# CITY OF ALBUQUERQUE

August 22, 2022

**Re: Kairos Power Expansion**  
**5201 Hawking Dr. SE**  
**Traffic Circulation Layout**  
Architect's Stamp XX-XX-XX (Q16-DA5000A)

Based upon the information provided in your submittal received 07-26-22, the above referenced plan cannot be approved for Building Permit until the following comments are addressed:

A-110

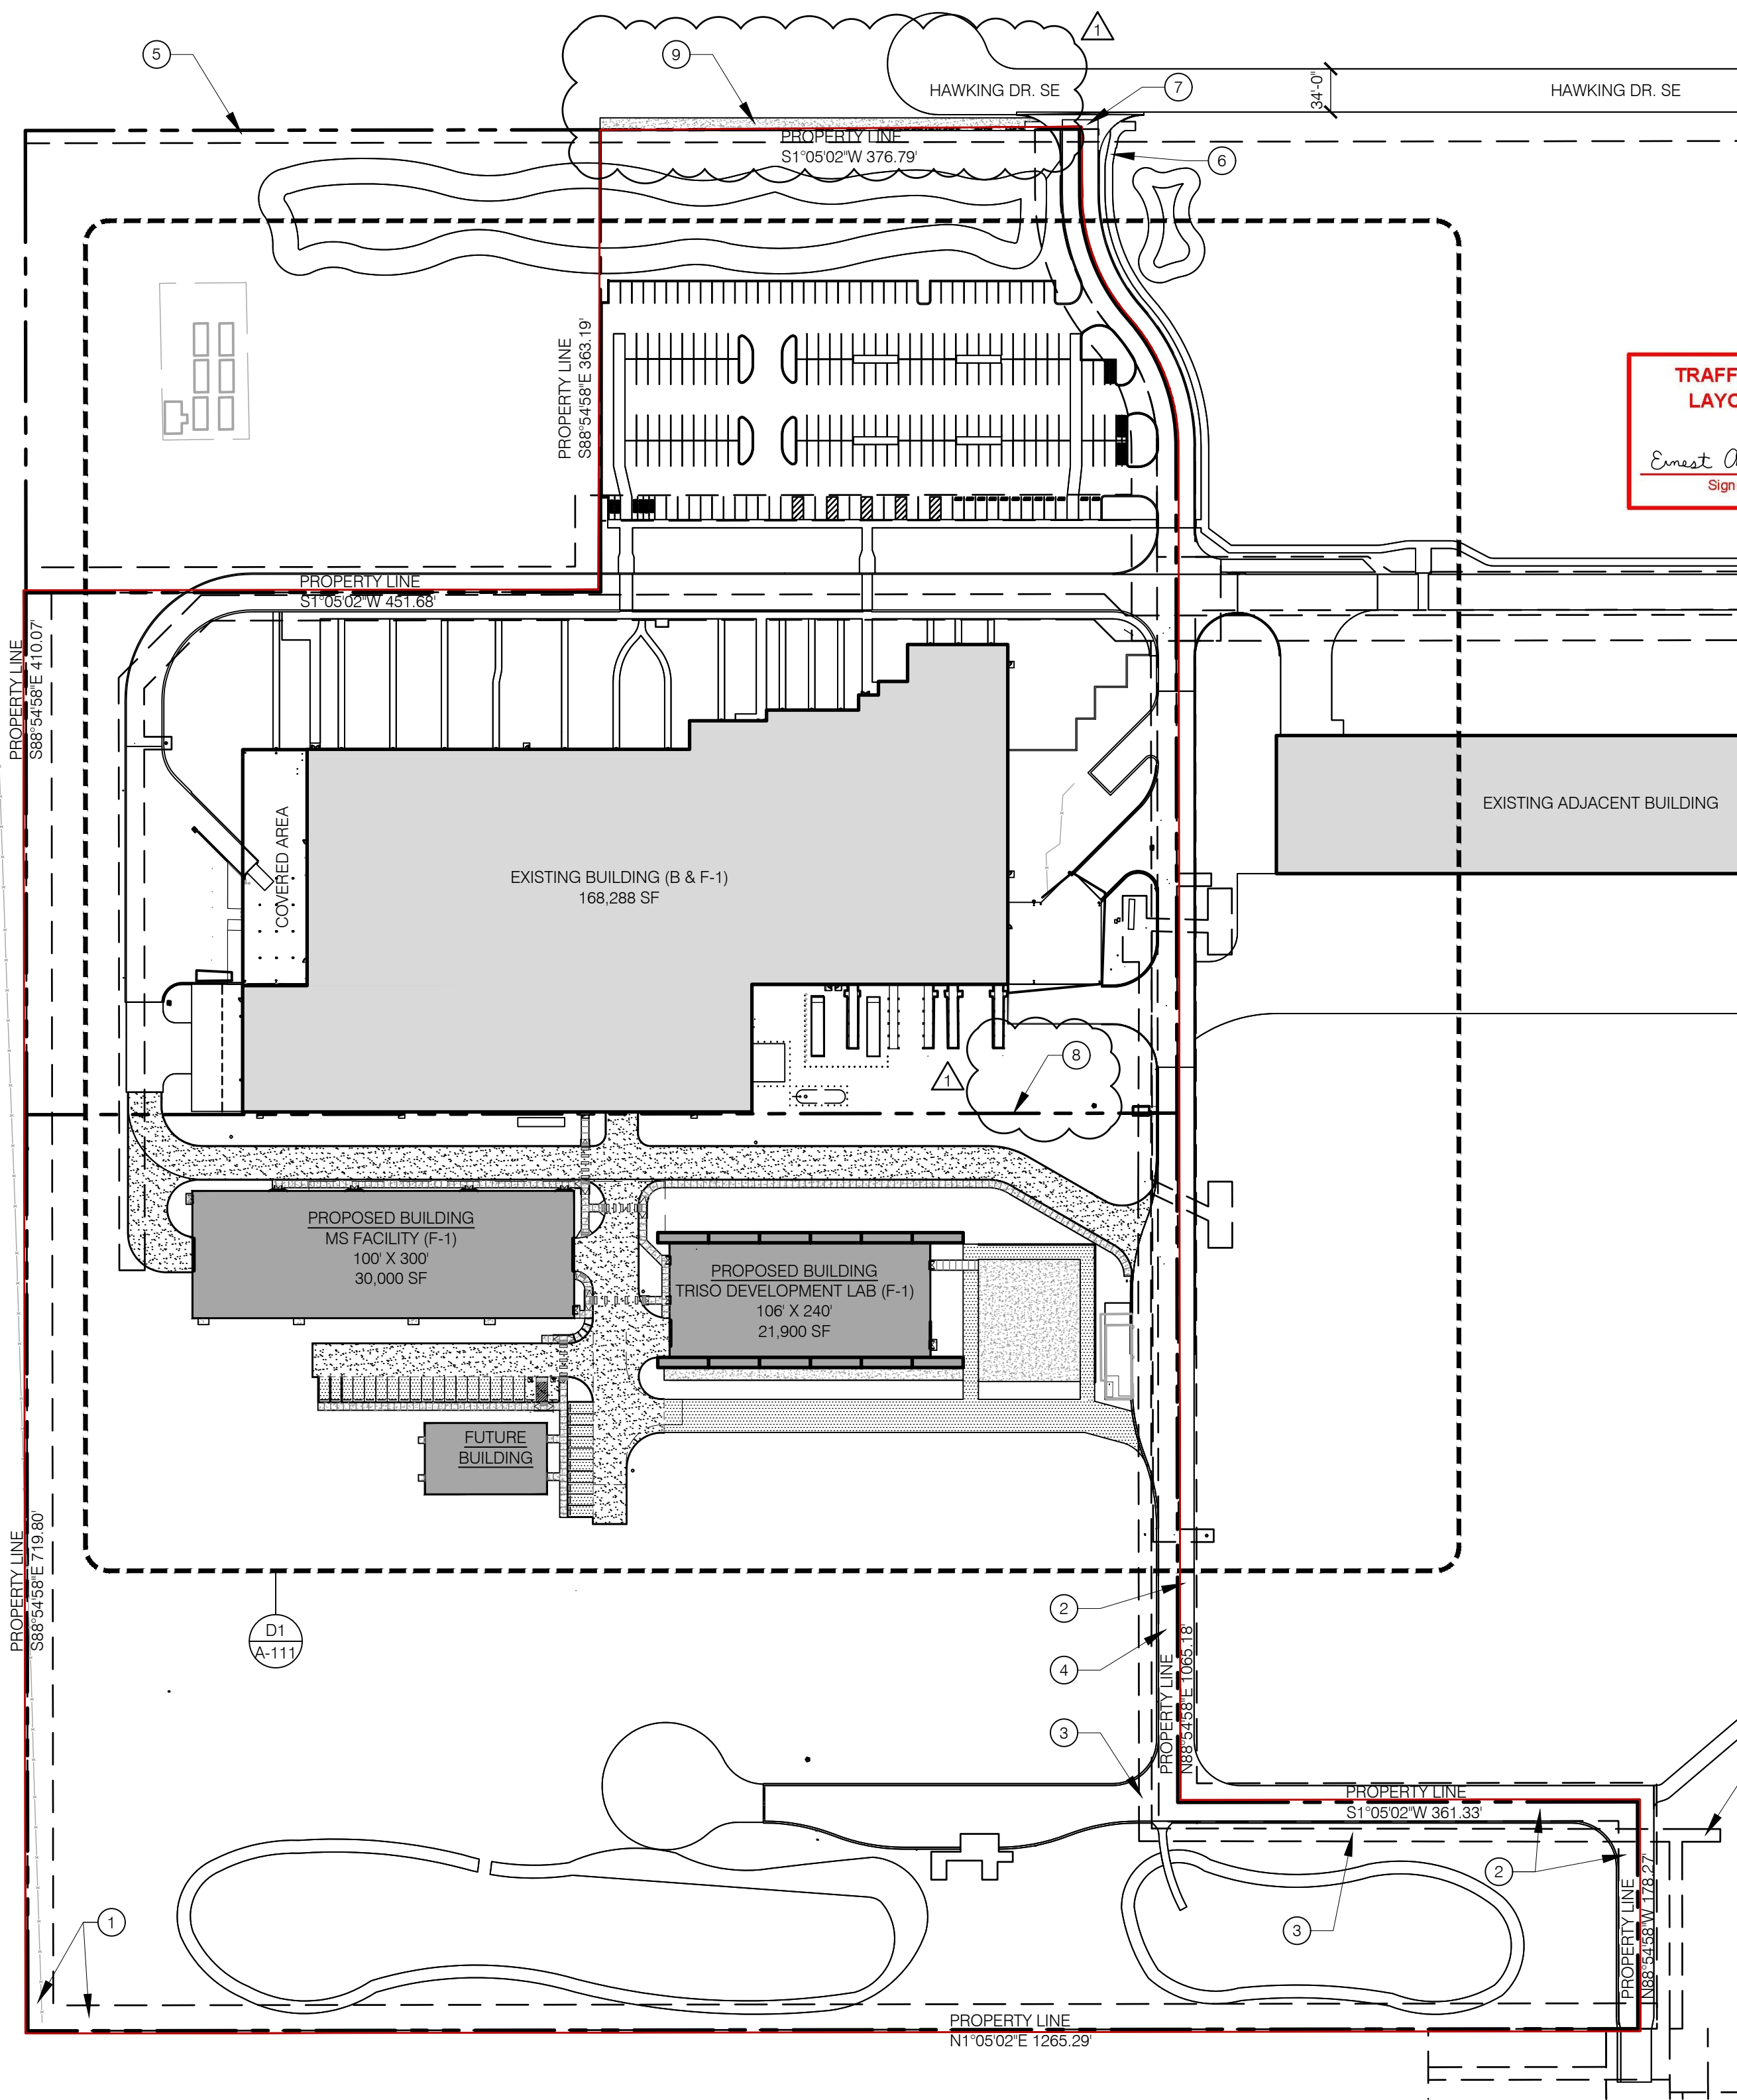
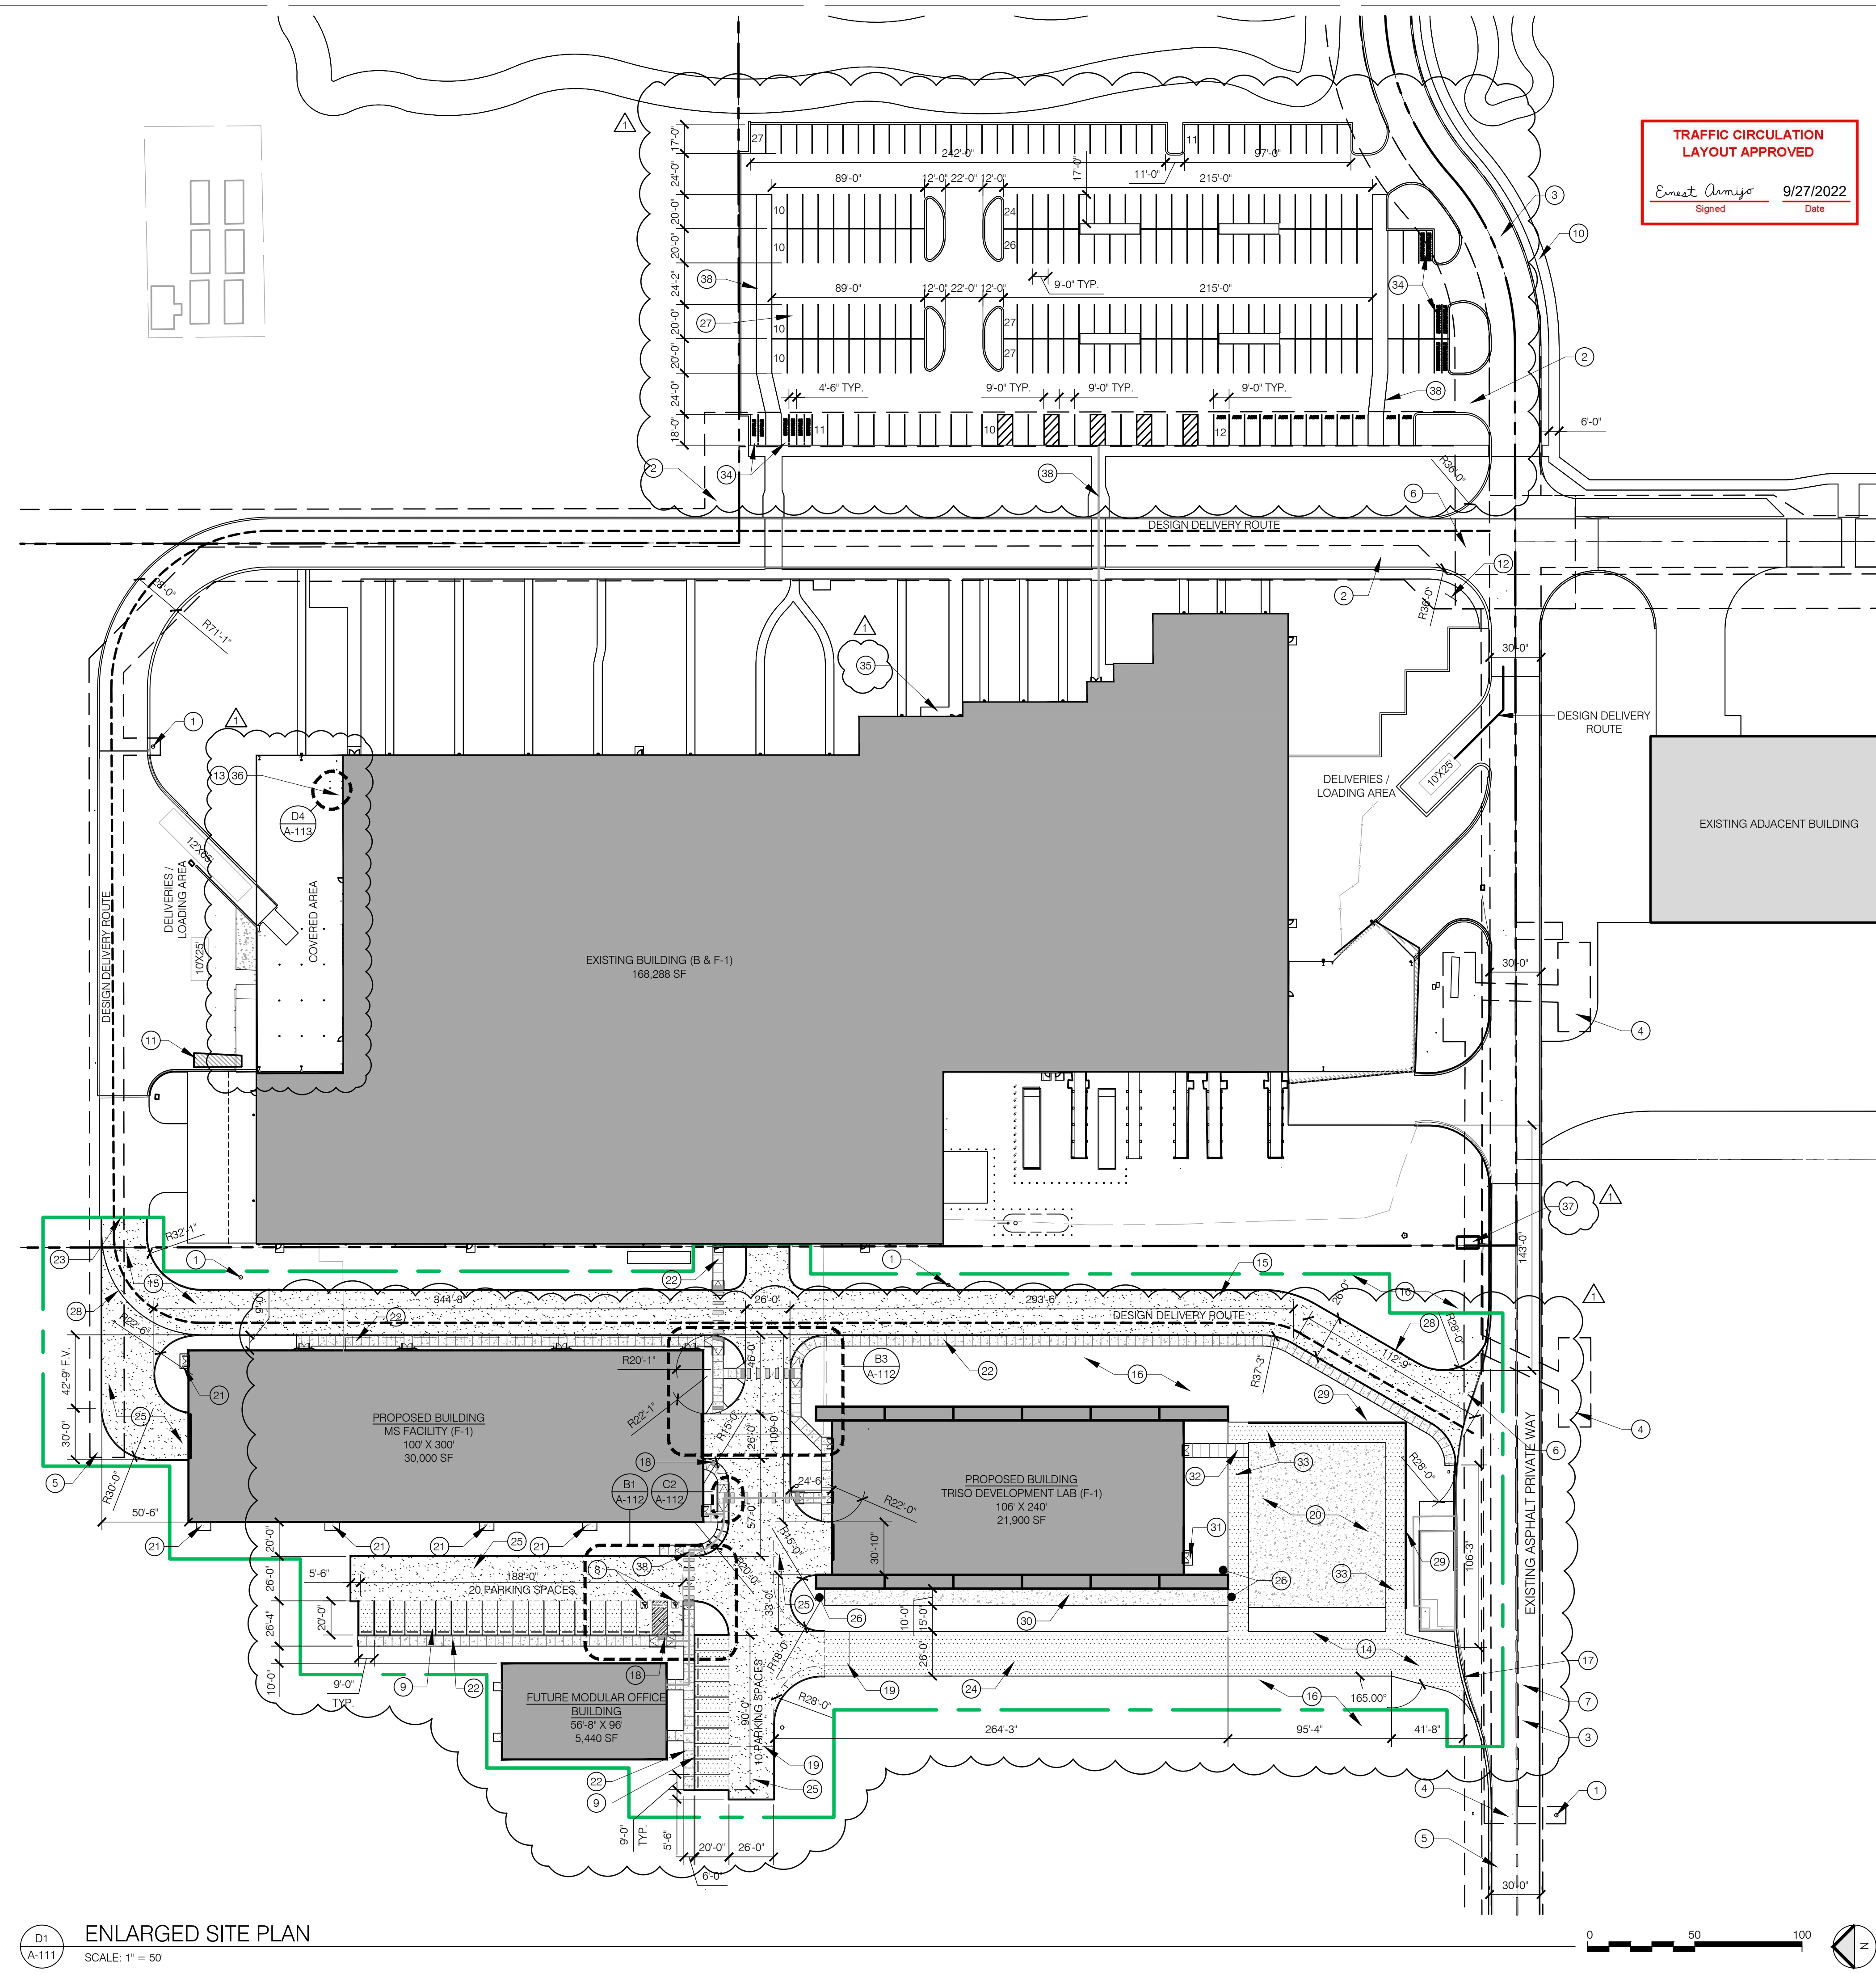
1. Clarify existing property lines and proposed property lines.
2. Please list the width and length for all existing and proposed parking spaces. Some dimensions are not shown.
3. The minimum parking stall dimensions are:

4. The ADA accessible spaces must include an access aisle. Van accessible aisles should be 8ft wide; all others should be 5ft wide.
5. The ADA accessible parking sign must have the required language per 66-7-352.4C NMSA 1978 **"Violators Are Subject to a Fine and/or Towing."** Please call out detail and location of signs.

6. The ADA access aisles shall have the words **"NO PARKING"** in capital letters, each of which shall be at least one foot high and at least two inches wide, placed at the rear of the parking space so as to be close to where an adjacent vehicle's rear tire would be placed. (66-1-4.1.B NMSA 1978)

7. ADA curb ramps must be updated to current standards and have truncated domes installed.
8. Keynote 18: provide all proposed ramps details and reference COA std dwg.

9. Keynote 22: please reference COA std dwg 2430 for the proposed sidewalk.
10. Keynote 17: is this will be one way or two-way drive aisle?

11. The minimum drive aisle dimensions are shown below

17. Per the IDO, a 6 ft. wide ADA accessible pedestrian pathway is required from the public sidewalk to the building entrances. Please clearly show this pathway and provide details.

18. Per DPM, a 6 ft. wide ADA accessible pedestrian pathway is required from the ADA parking stall access aisles to the building entrances. Please clearly show this pathway and provide details.

19. ADA accessible pedestrian pathway should not be placed behind parking space or adjacent to a vehicular way. Vehicle and pedestrian/wheel chair conflicts should be avoided as much as possible.
